KITTITAS COUNTY COMMUNITY DEVELOPMENT SERVICES

September 2, 2010

RE: Carpenter Boundary Line Adjustment, BL-10-00030

carpenter

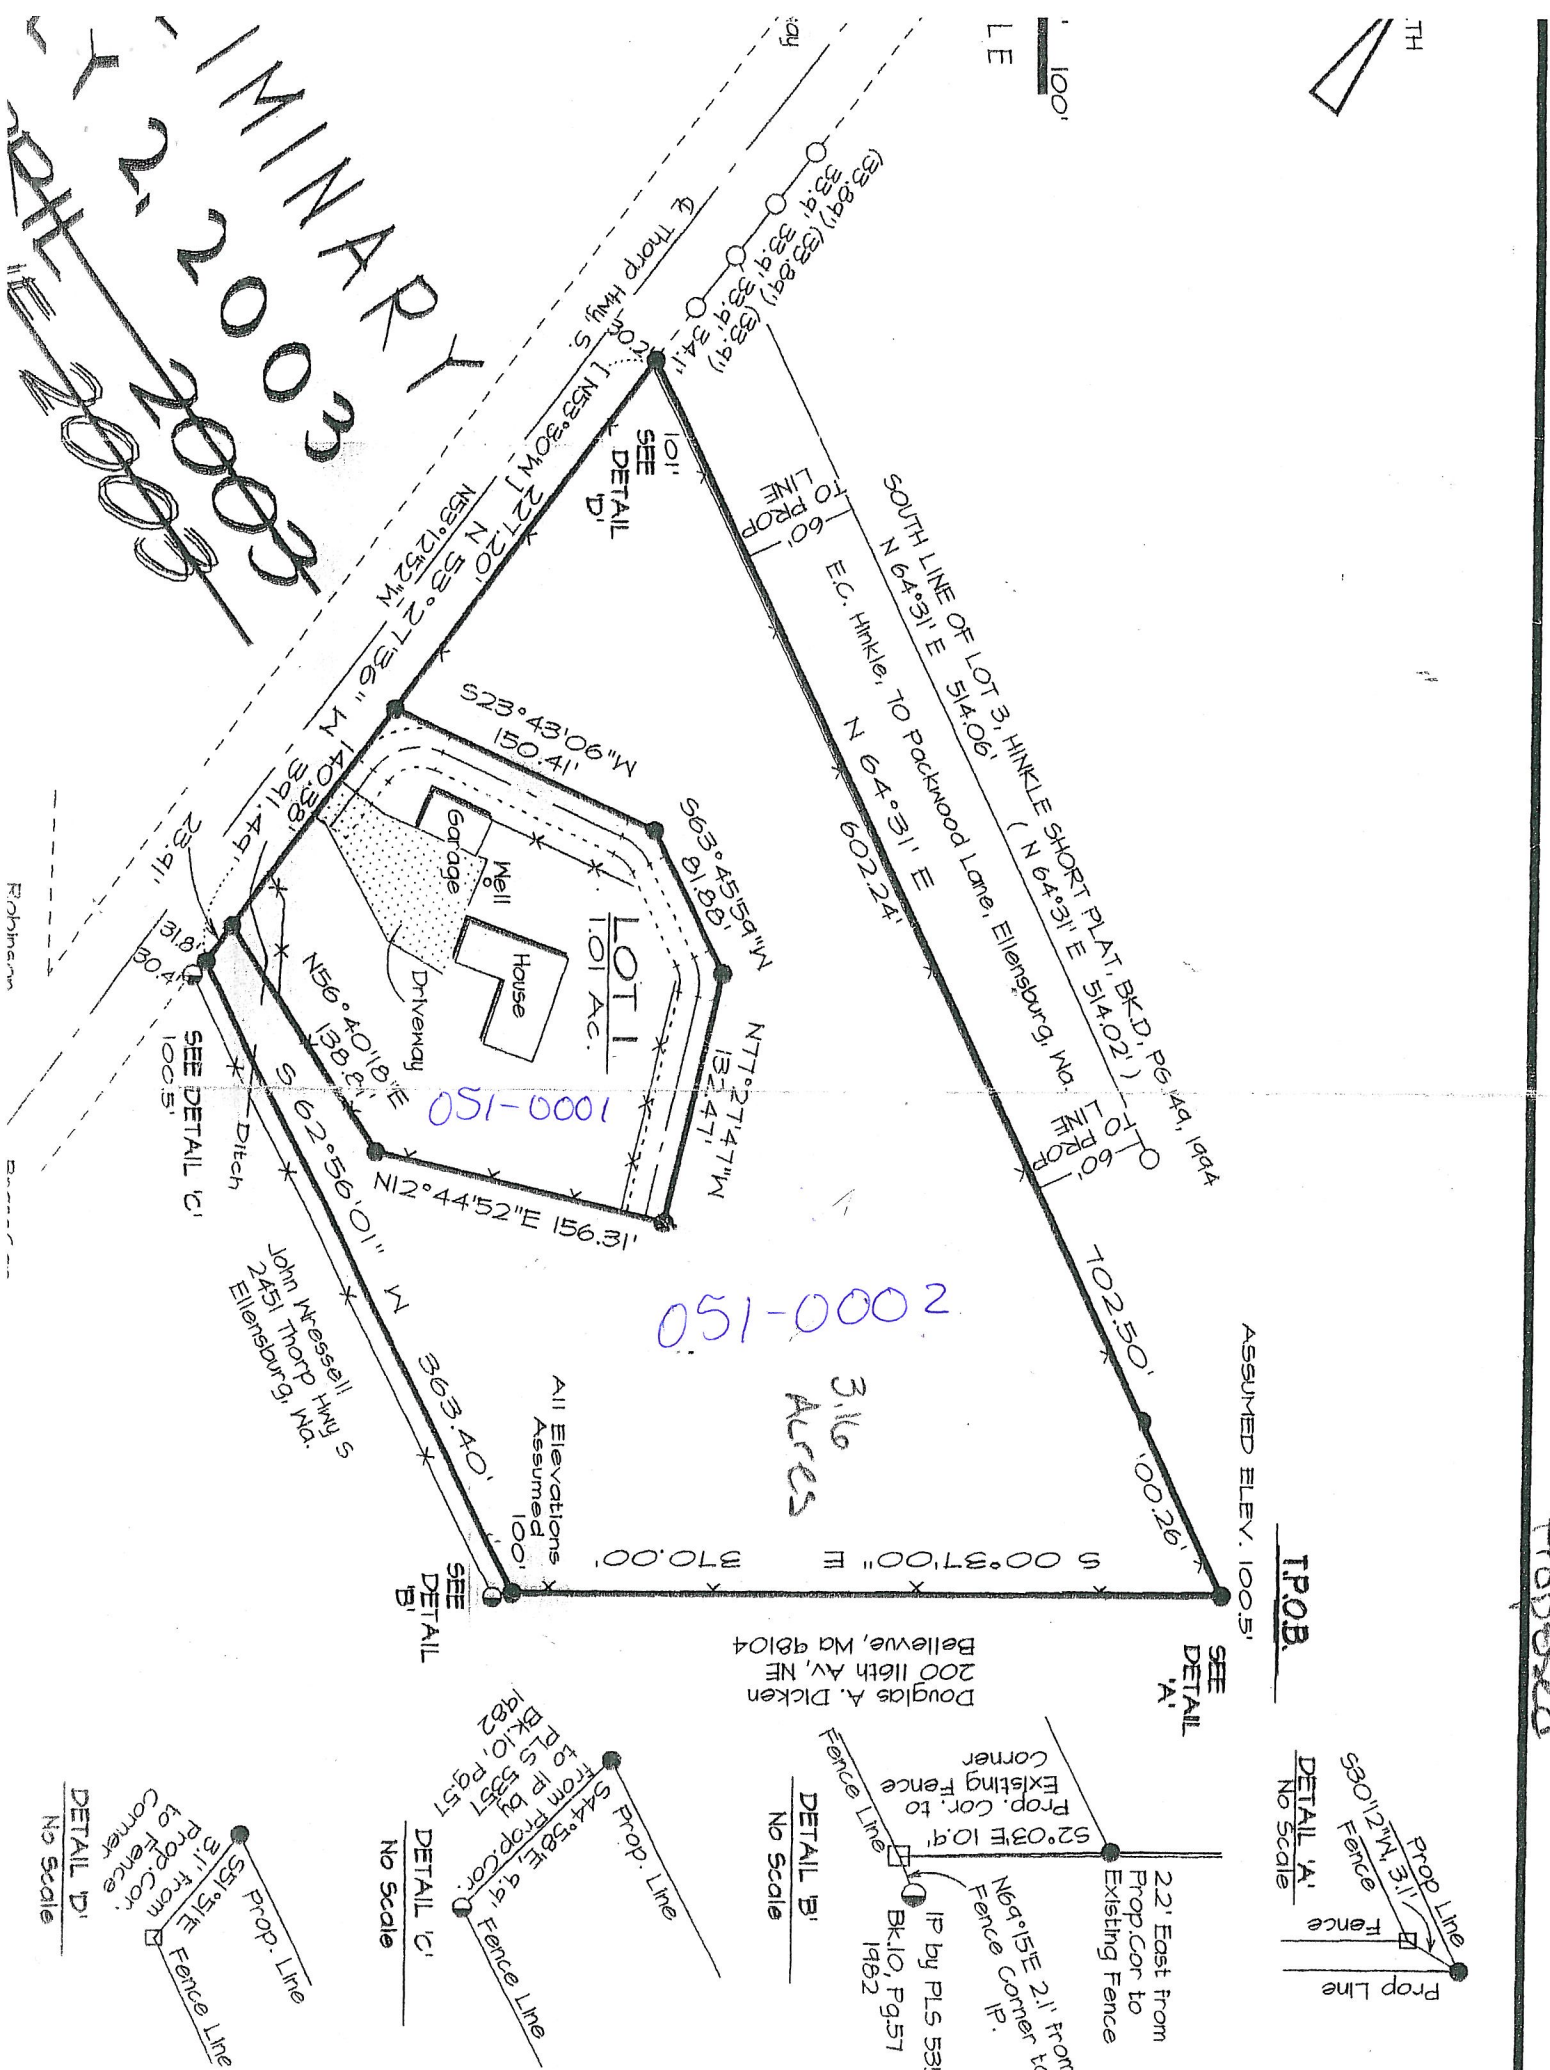
4. Wellhead protection areas KCC 17A.08.020; All non-community wells must be placed a minimum of 50 feet from property lines. OSDS Location KCC 13.04.080; Septic tanks must be located 5 feet from the property line, and disposal areas at least 10 feet from the property line. Verification of these setback requirements will need to be provided either on the recorded survey, or through a revised unified site plan with accurate dimensions.
